# CITY OF ALBUQUERQUE

January 11, 2011

**Re: Chelwood Elementary School Handicap Parking Spaces  
Grading Plan  
Engineer's Stamp dated 1-07-11 (J22/D005)**

GRADING PLAN
SCALE: 1" = 10'

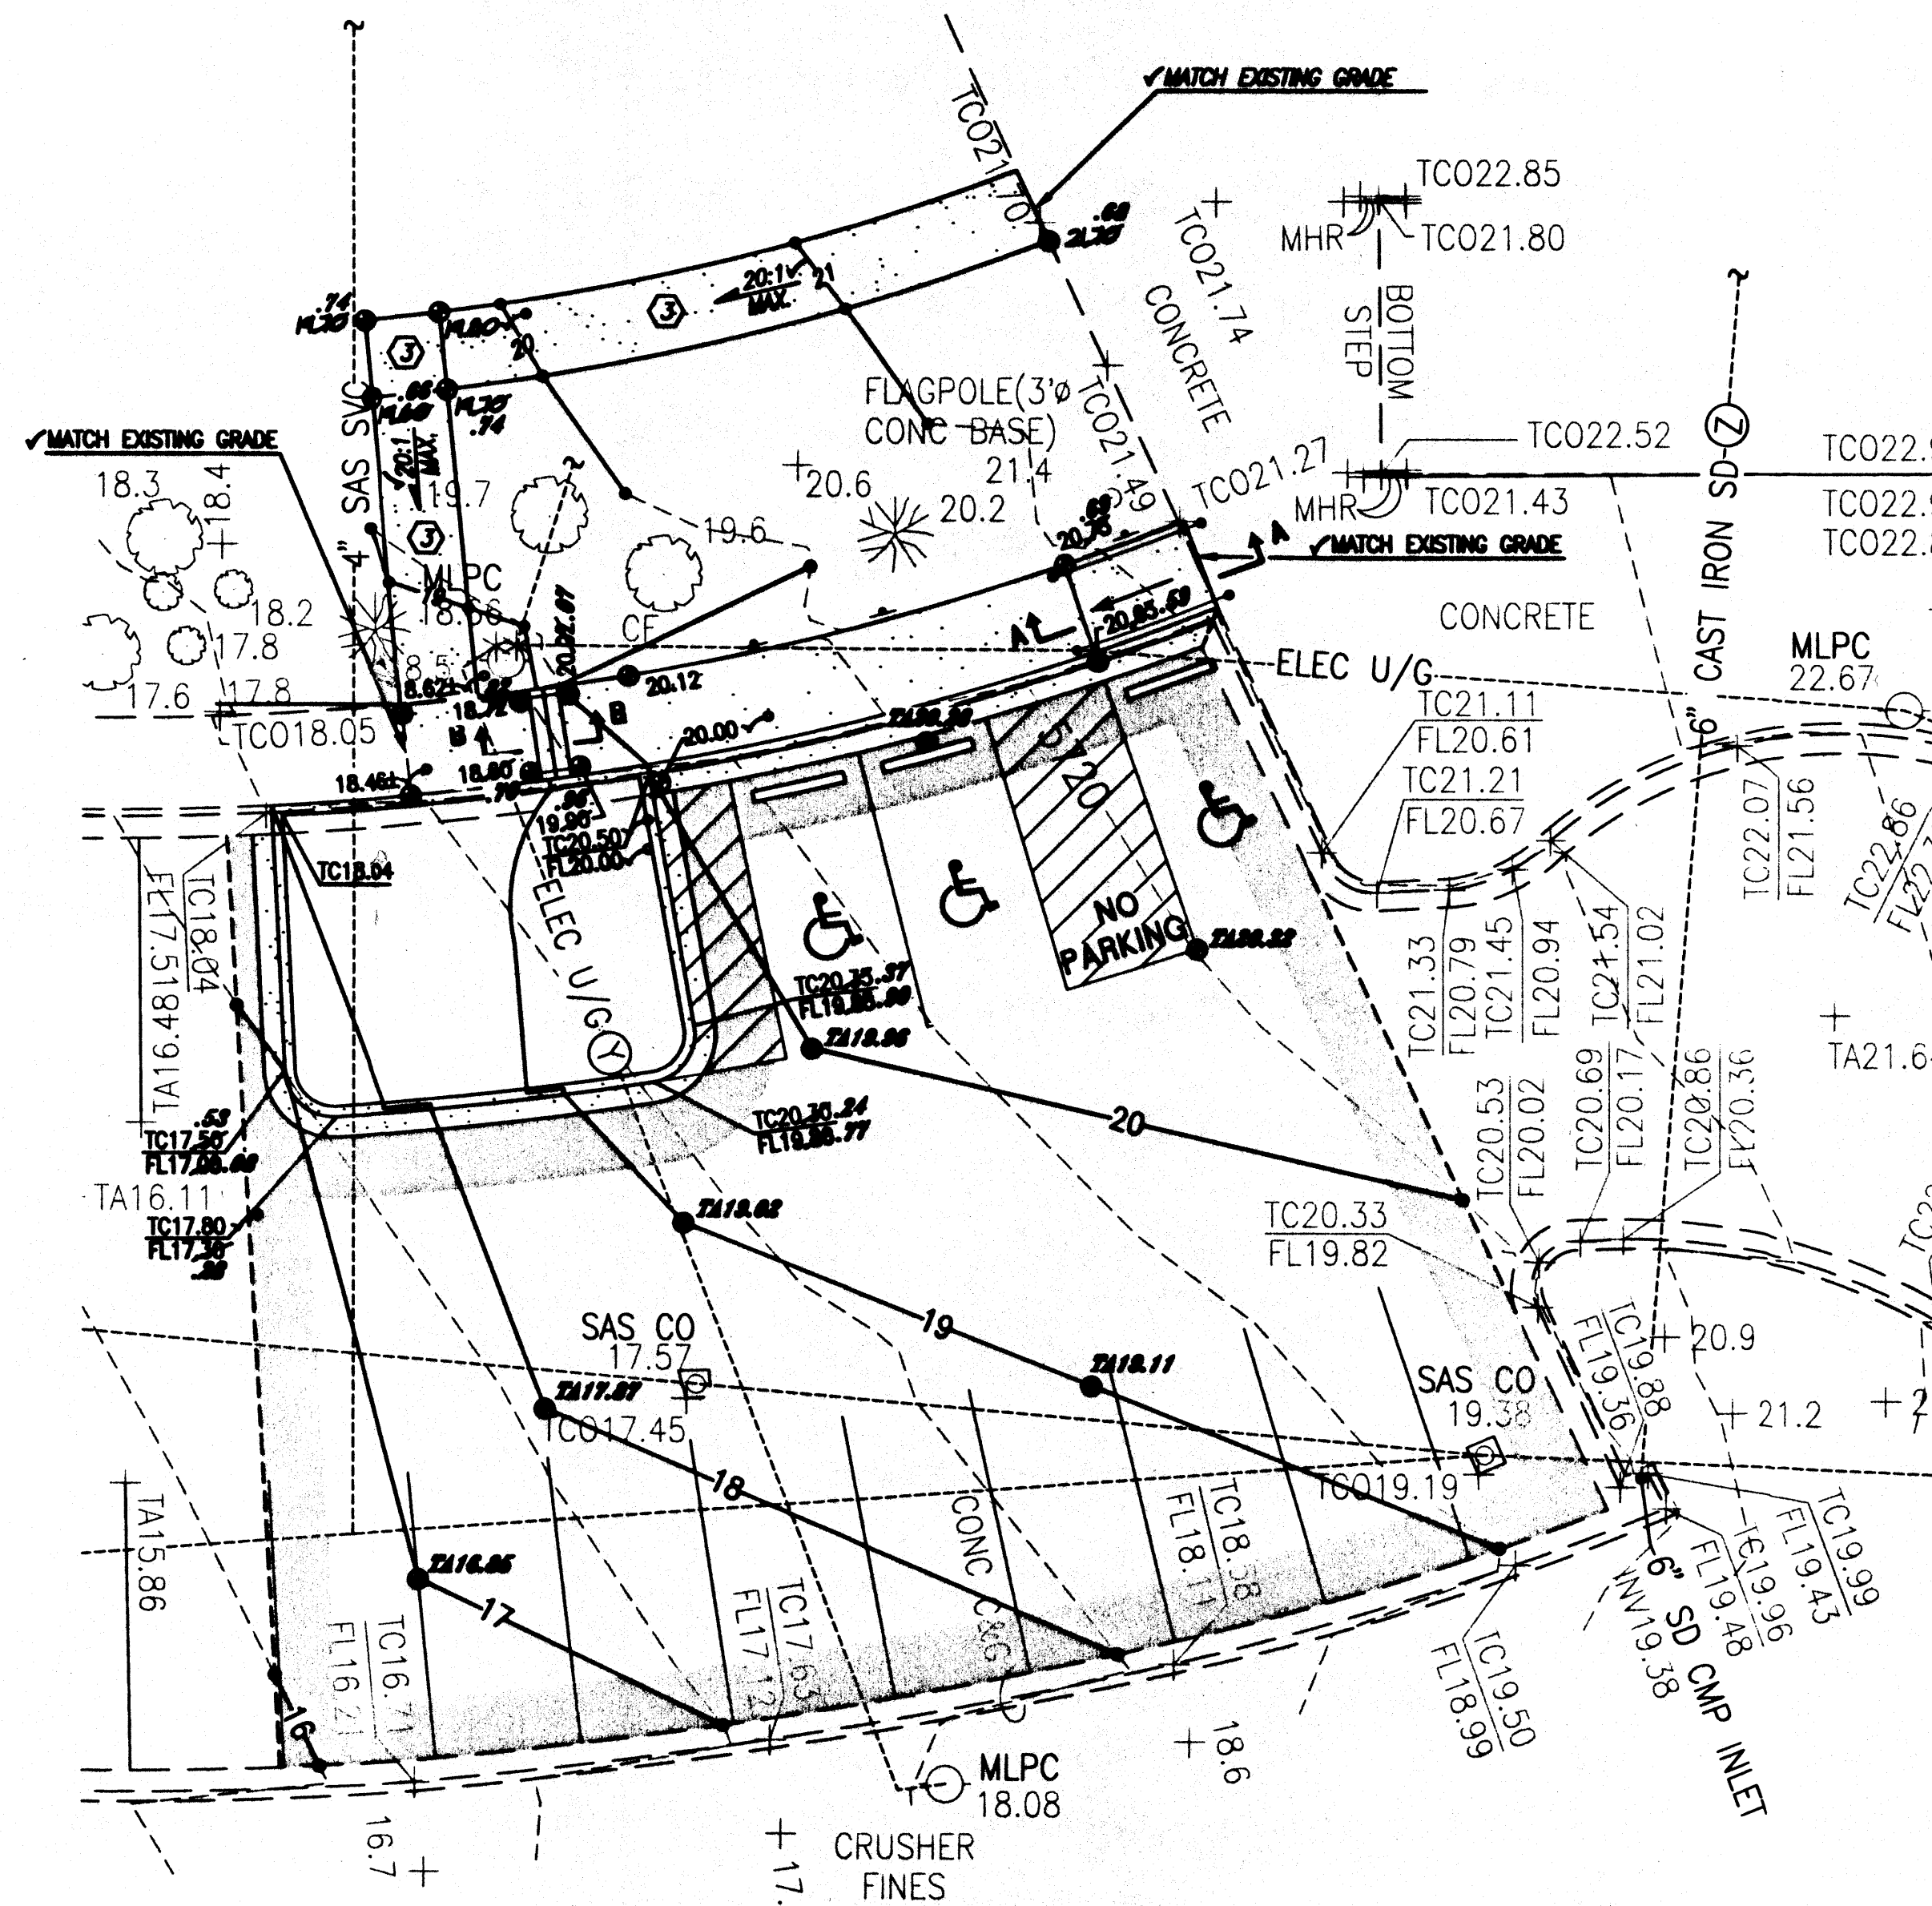
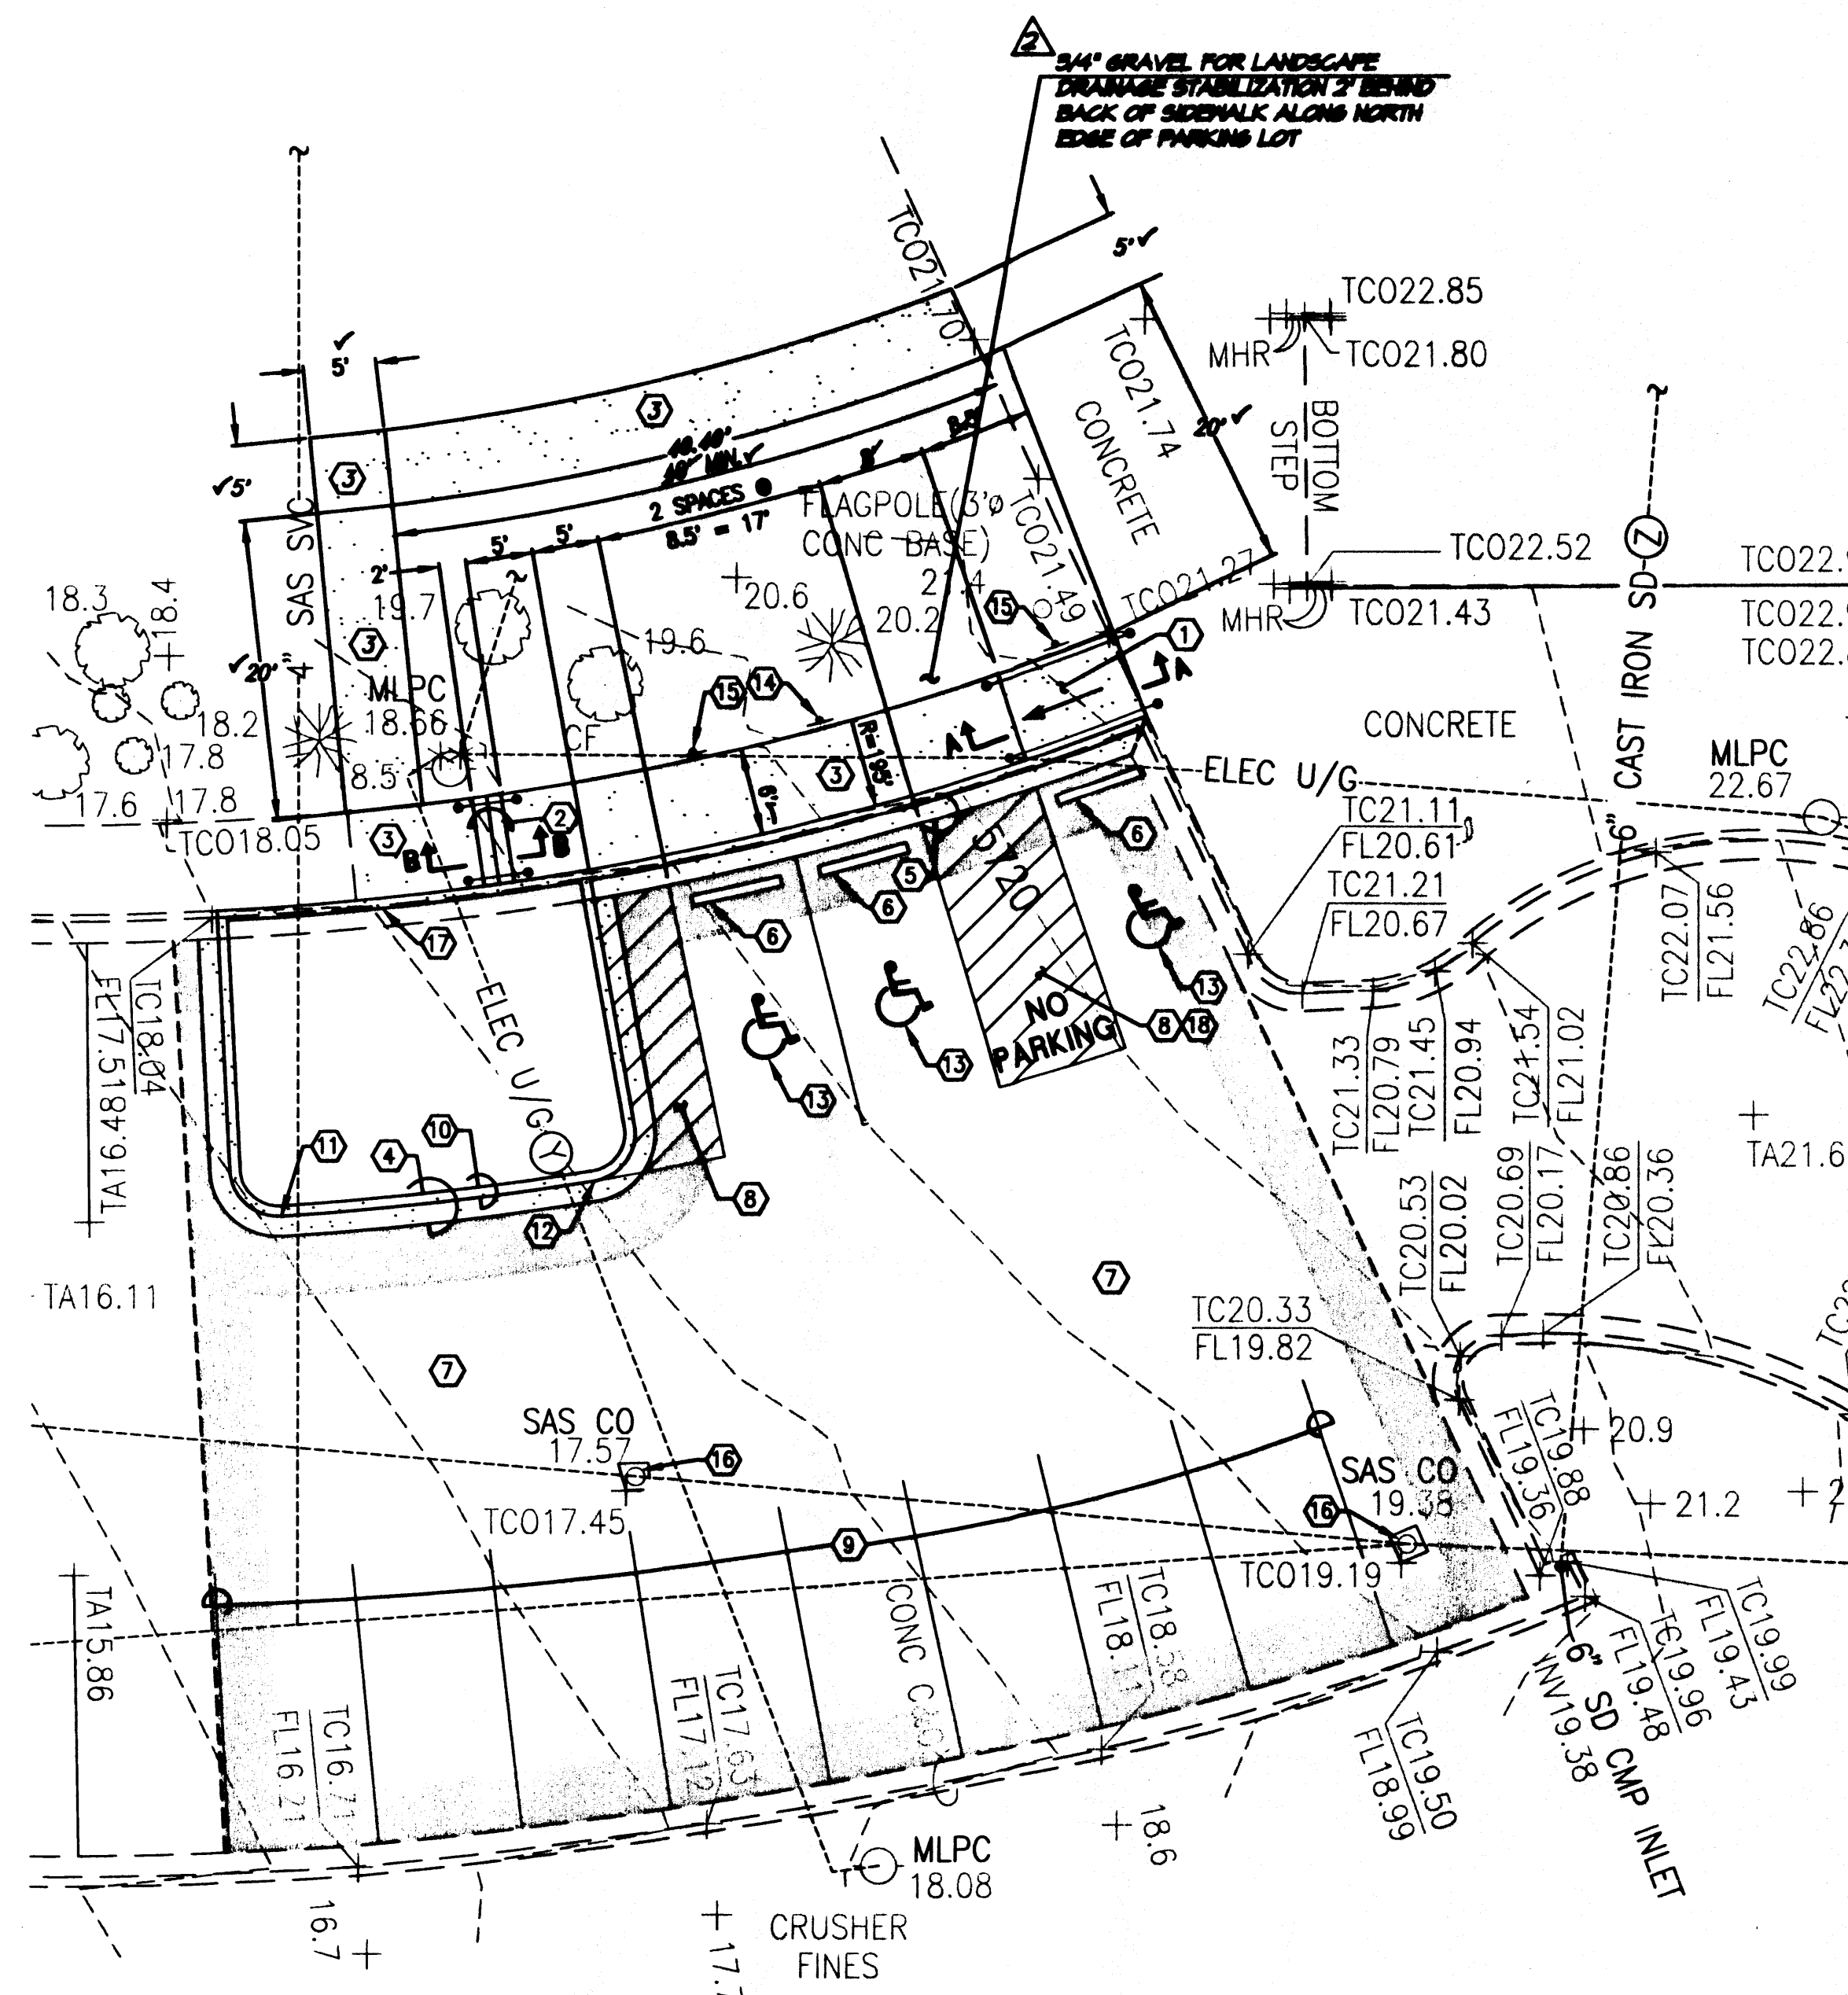
Hydrology is requesting that proposed landscape area be depressed to retain/infiltrate the rain that falls in this area.
